RE: Harnett County Land Use Application 06-5-16262

On December 11, 2006, an Environmental Health Specialist from the Harnett County Health Department attempted to evaluate your property for the purpose of issuing an Improvement Permit. This individual was unable to evaluate your property for one or more of the following reasons.

RE: Lot # 2, Nature's Crossroads, Phase I - Harnett County, NC

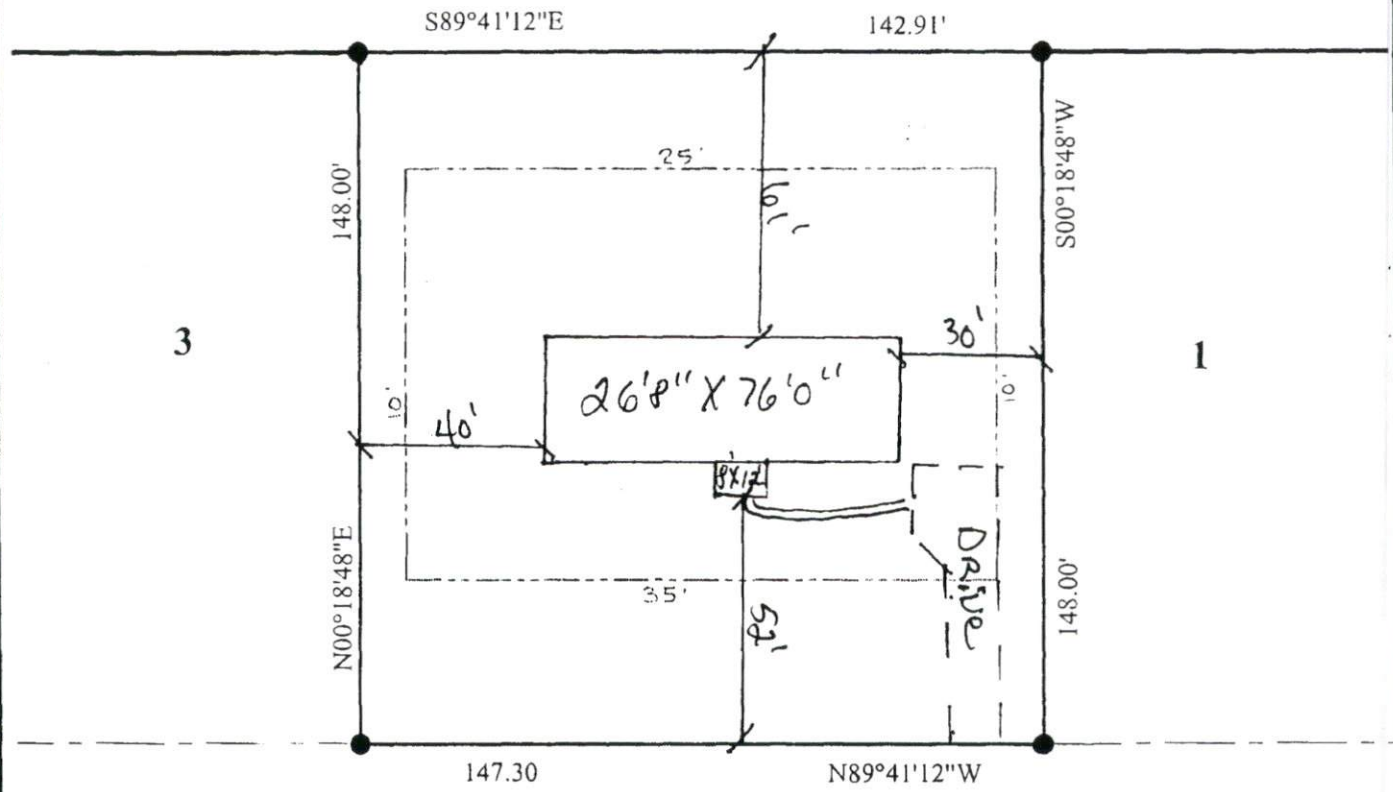
- 1. Property lines/corners not marked or labeled
- 2. House corners not marked or labeled
- 3. Directions not clear to property
- 4. Property needs brush or vegetation removed
- 5. Backhoe pits required (due to rocky soil conditions)
- 6. Other *Move house as shown on attached sheet. Please make changes at Central Permitting.*

When you have completed #1, 2 & 6 please call 910-893-757 to confirm that the items mentioned have been corrected, we will then reschedule your property for evaluation.
